Application for Planning Permission

Development: Amendment to LU/59/25/PL to allow for the formation of overspill car park, rationalisation of existing car park and formation of residents garden including fence panels (resubmission following LU/310/24/PL). This application may affect the setting of listed buildings and is in CIL Zone 2 (Zero Rated) as other development.

Location: Strawberry Field Courtwick Lane Littlehampton BN17 7PD

DRAWING TITLE:
101 - P1 - PROPOSED SITE PLAN
PROJECT NO: **24890** DATE: **DEC 24** SCALE: **1:500 @ A3**

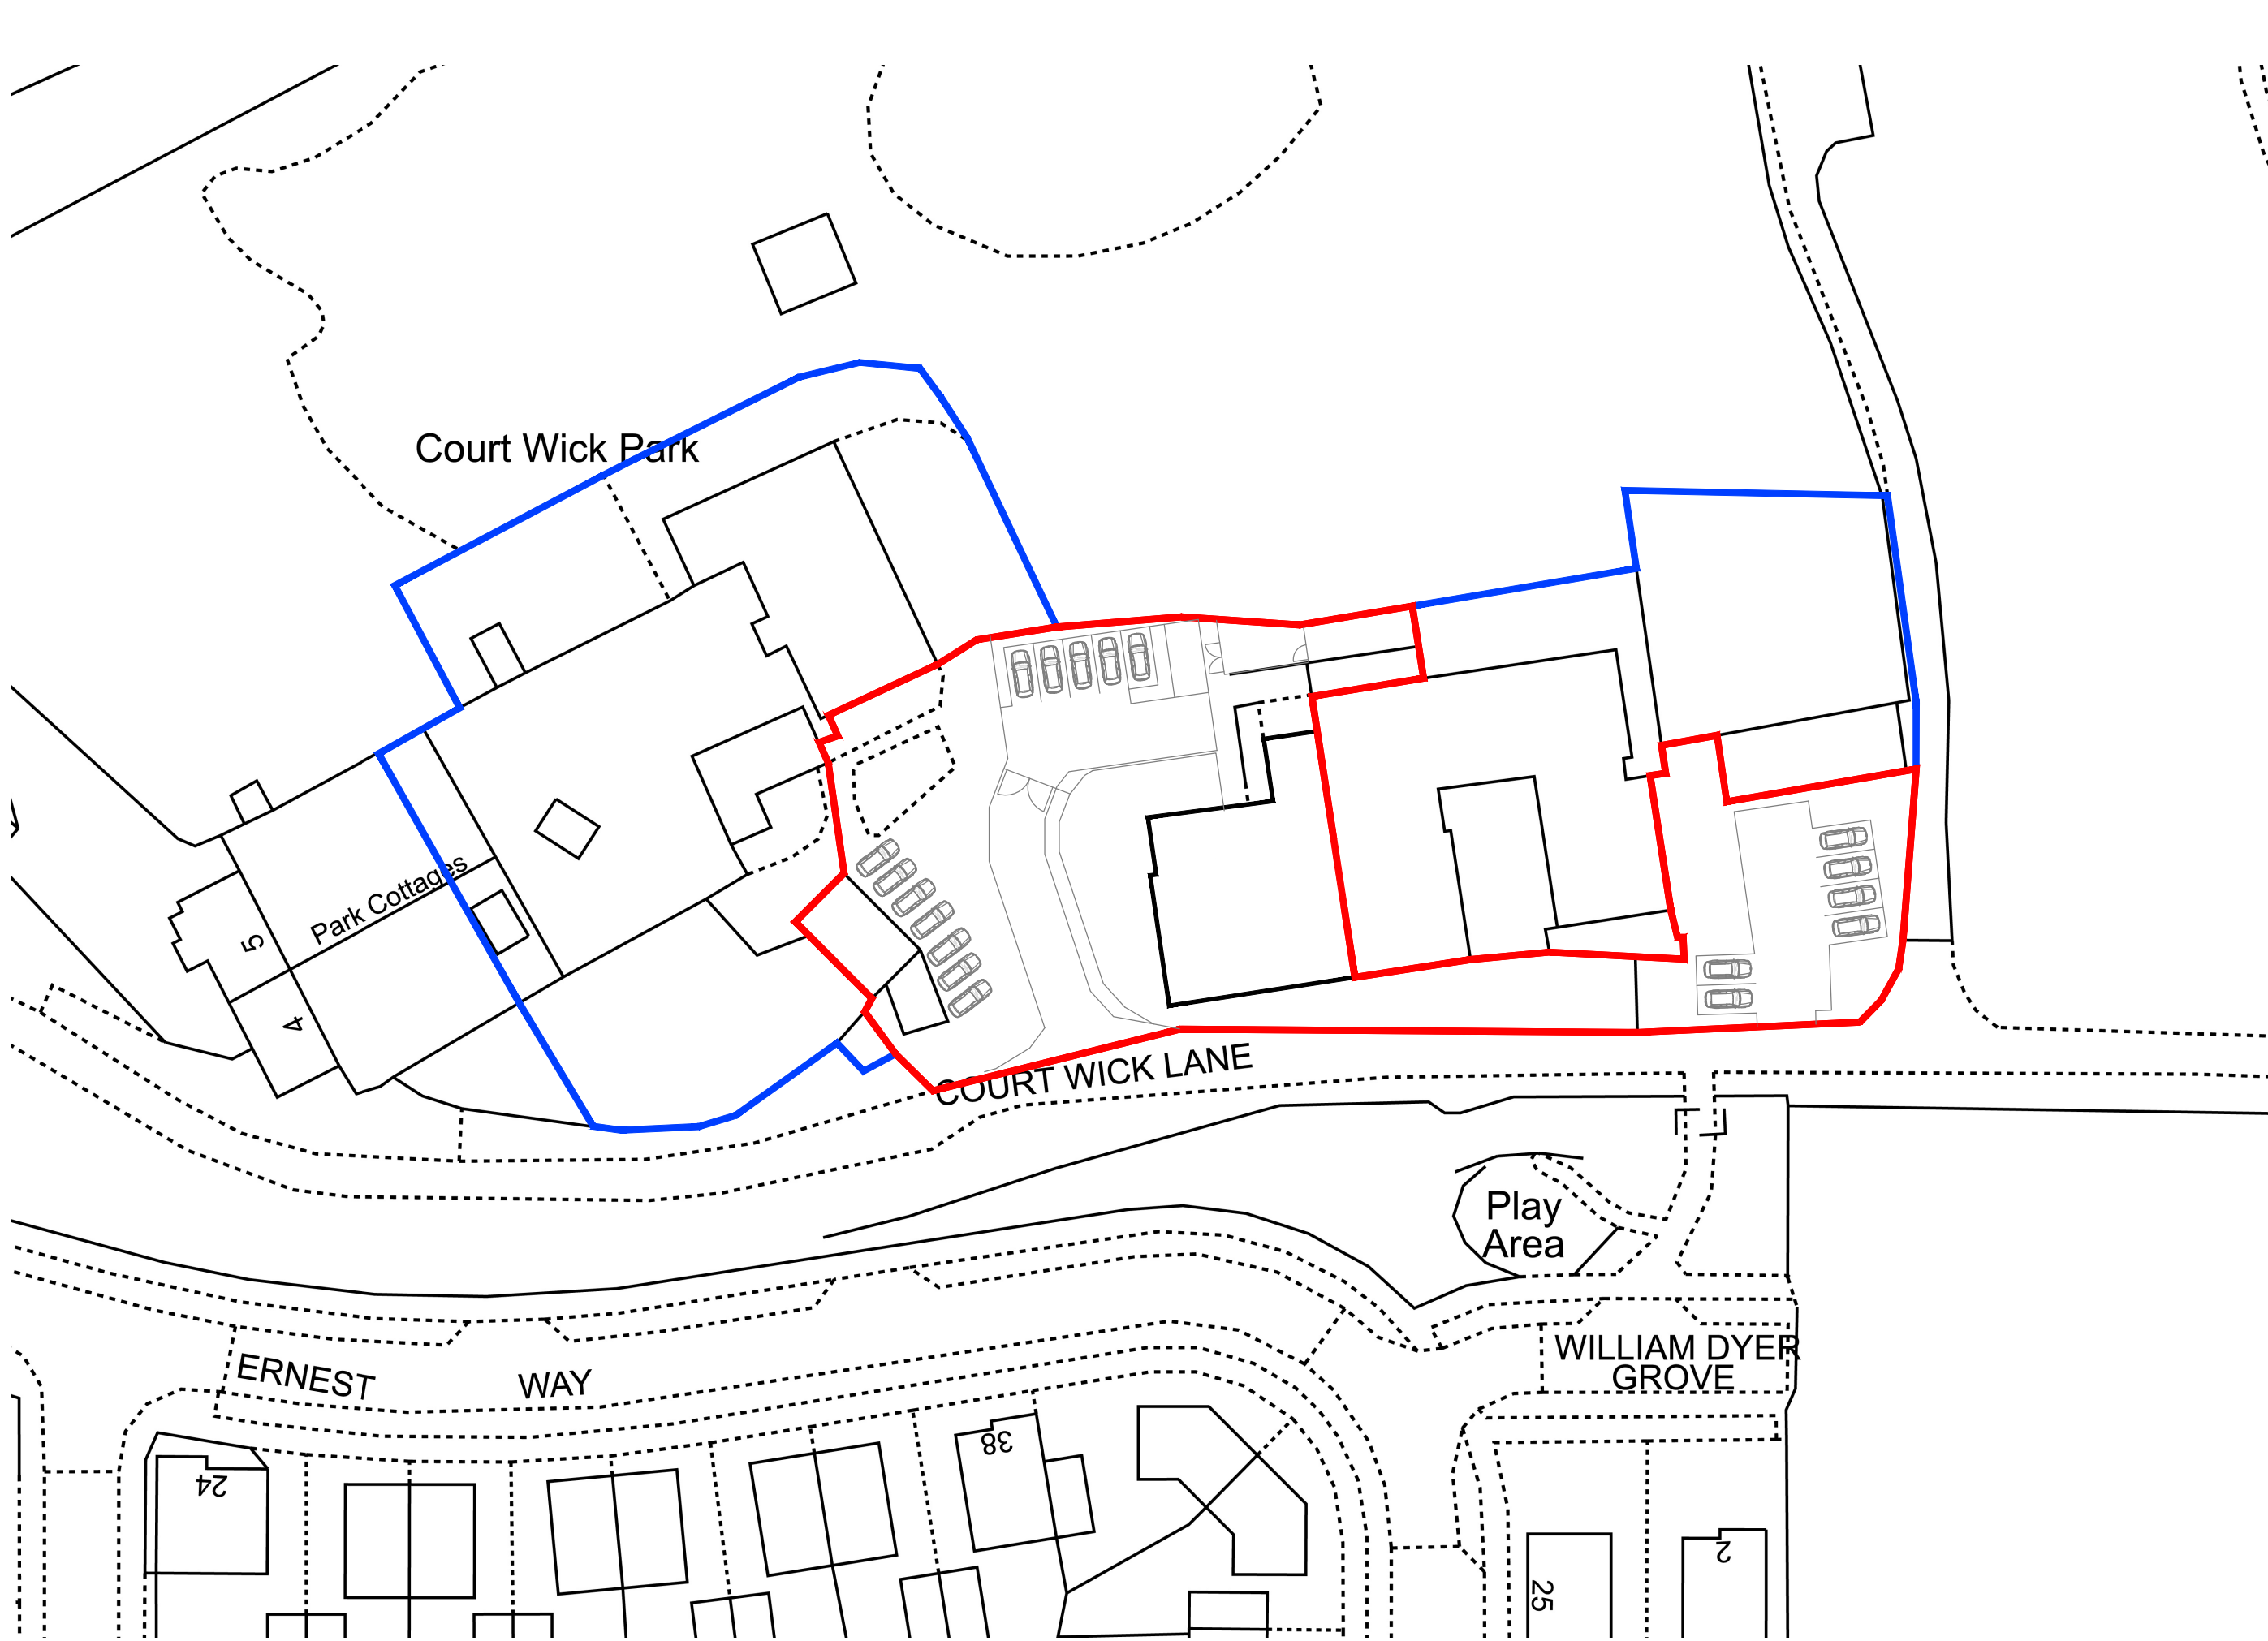
The application form says that there are 18 total parking spaces while the proposed site plan only shows 11. Please clarify where the other 7 spaces are located.
